**Section 96A of the Town & Country Planning Act 1990 (as amended)
Town and Country Planning (Development Management Procedure) (England) Order 2015 (as amended) - Article 10**

Non-material amendment following grant of Hybrid application BE/135/18/PL change the internal layout of Unit 8 (A1 Food store), within the Full application, and move 2 No. windows and 1 No. door on the rear (west) elevation.

Salt Box Field Land off Rowan Way Bognor Regis PO22 9NW

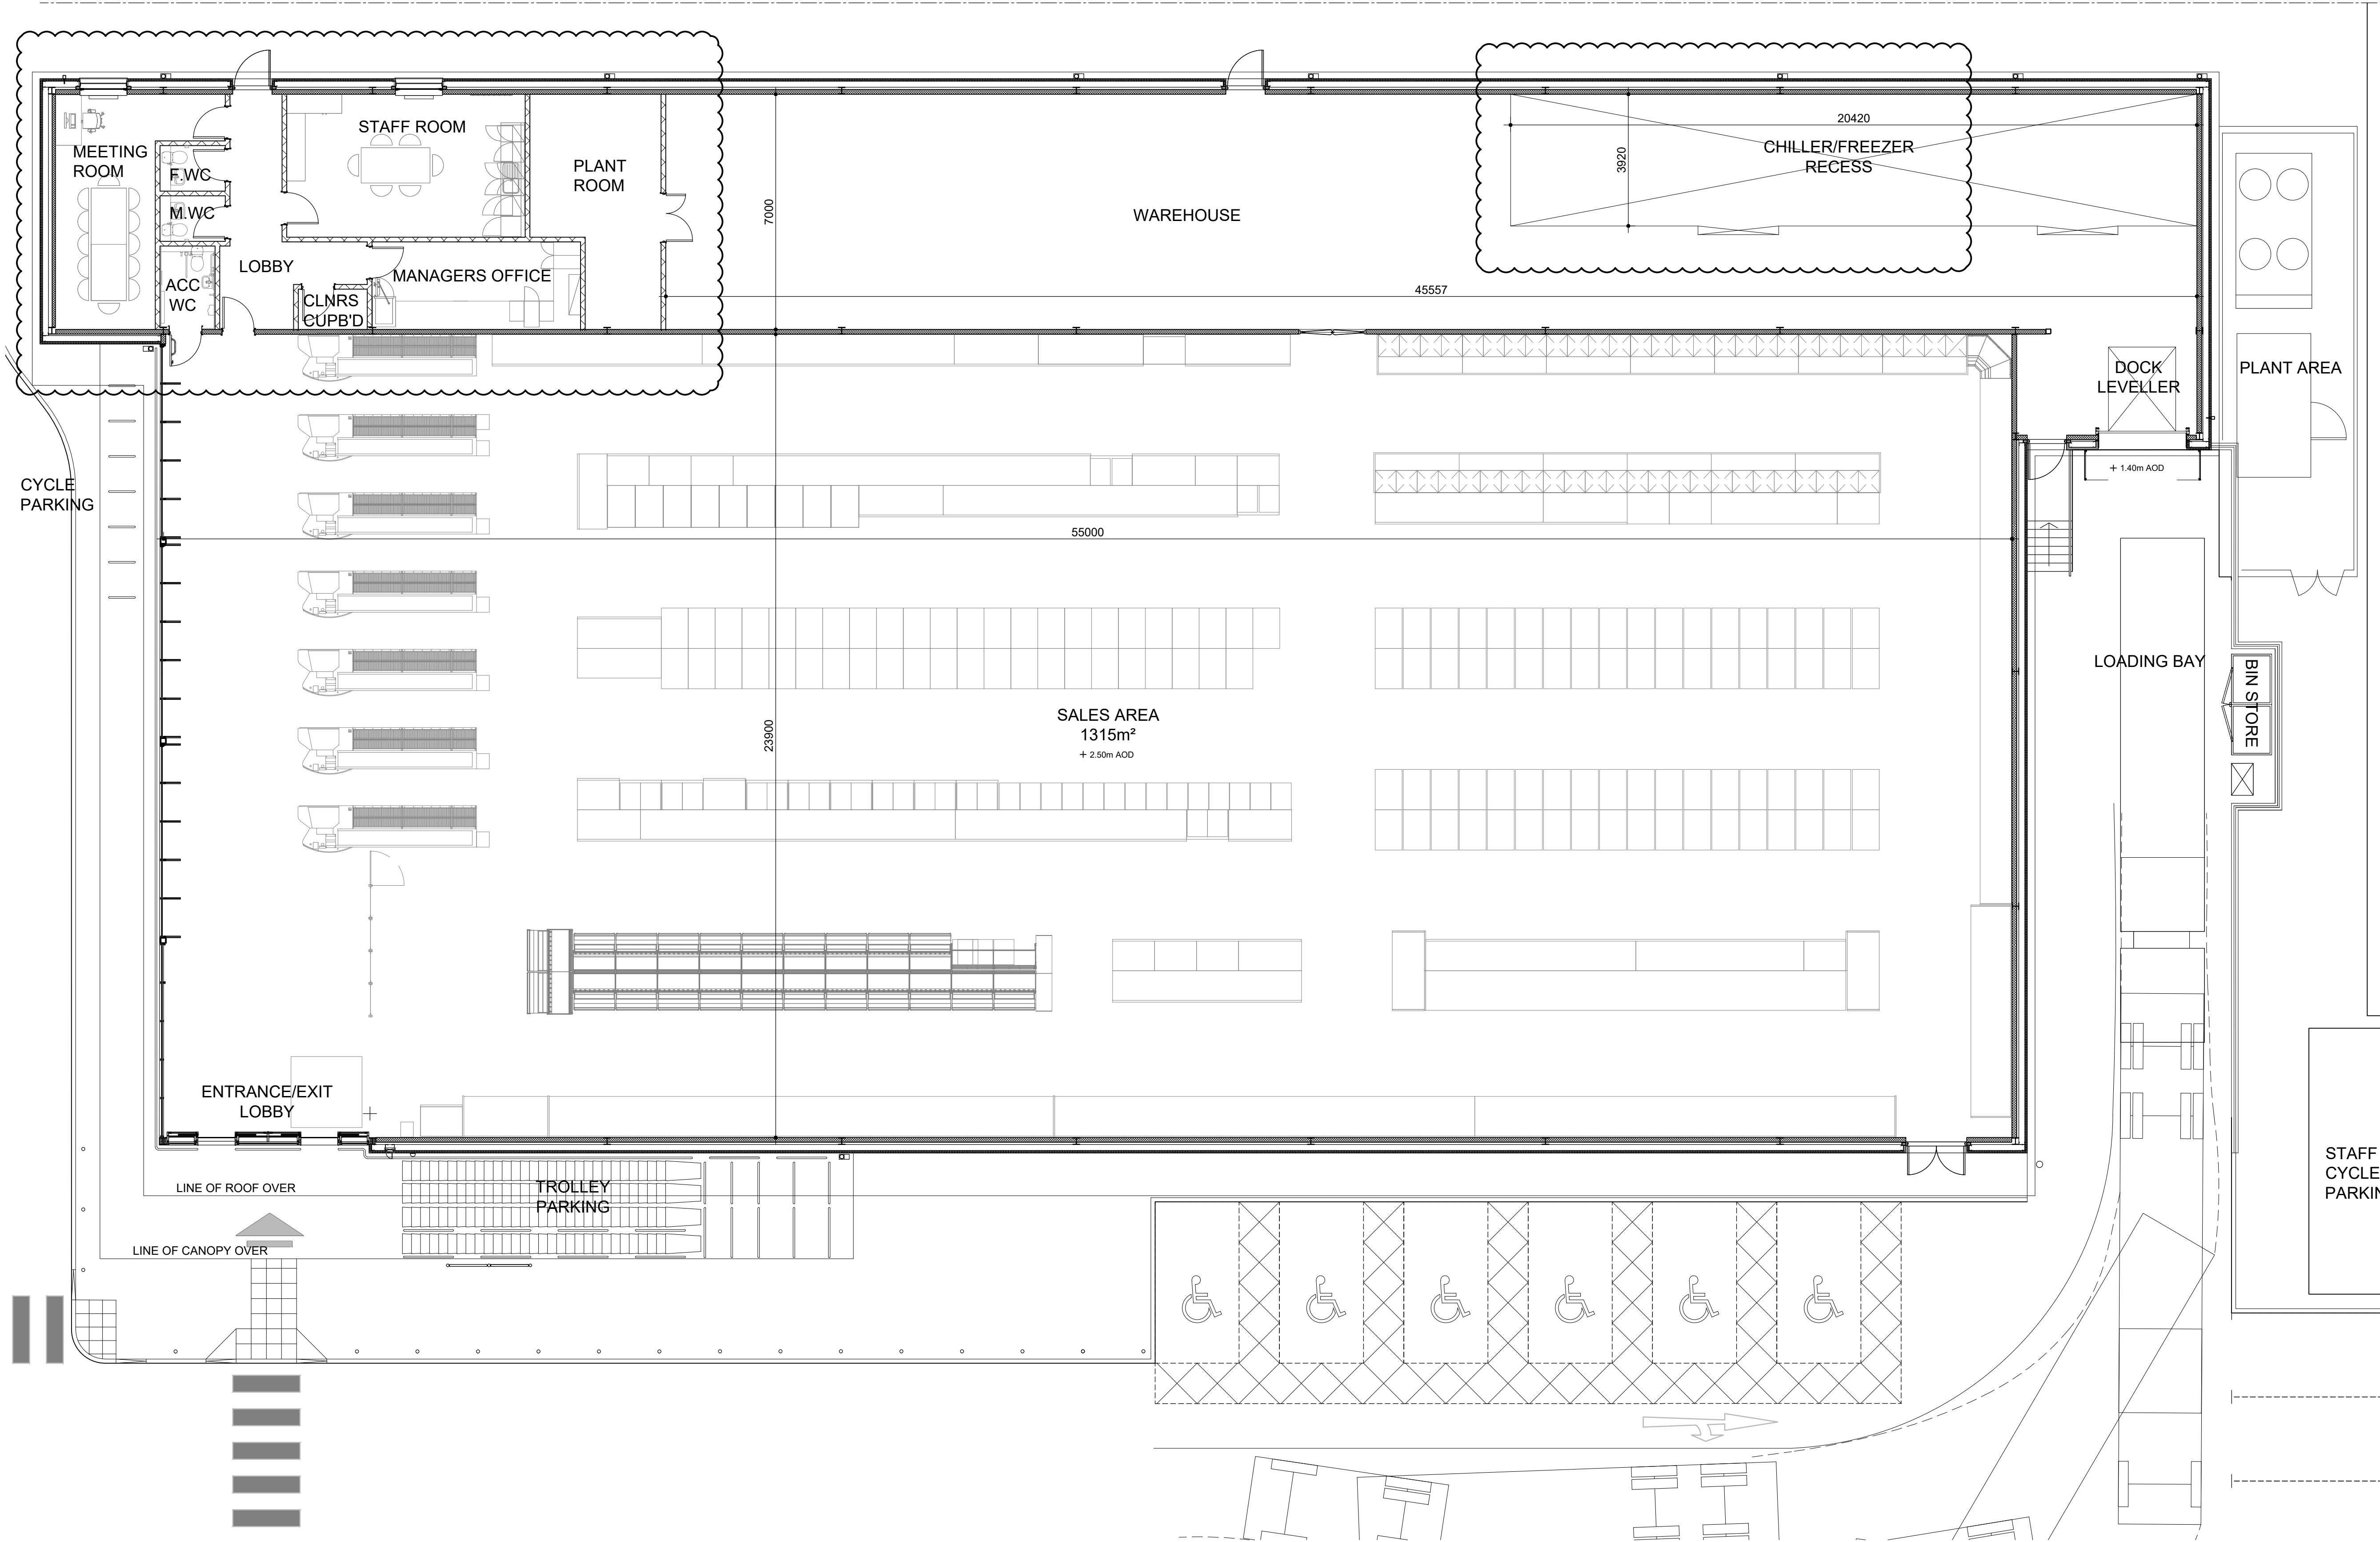
The reasons that these proposals have been accepted as Non-Material Amendments is because 2 windows and a door on the rear (west) elevation of Unit 8 (the Class A1 Foodstore) have had to move due to internal changes in the internal layout of the building and it can therefore be considered under section 96A of the Town and Country Planning Act 1990.

Please note that Drawing No. 1744-P01-Rev. D - "Site Masterplan Block Plan", Drawing No. 1744-UF-P02 Rev. A - "Unit 8 Proposed Ground Floor Plan and Drawing No. 1744-UF-P04 Rev. D - "Unit 8 Proposed Elevations" now form part of the approved planning documents and drawings for the full planning permission BE/135/18/PL and supersede Drawing No. 1744-P01-Rev. C - "Site Masterplan Block Plan", Drawing No. 1744-UF-P02 - "Unit 8 Proposed Ground Floor Plan and Drawing No. 1744-UF-P04 Rev. C - "Unit 8 Proposed Elevations", respectively.
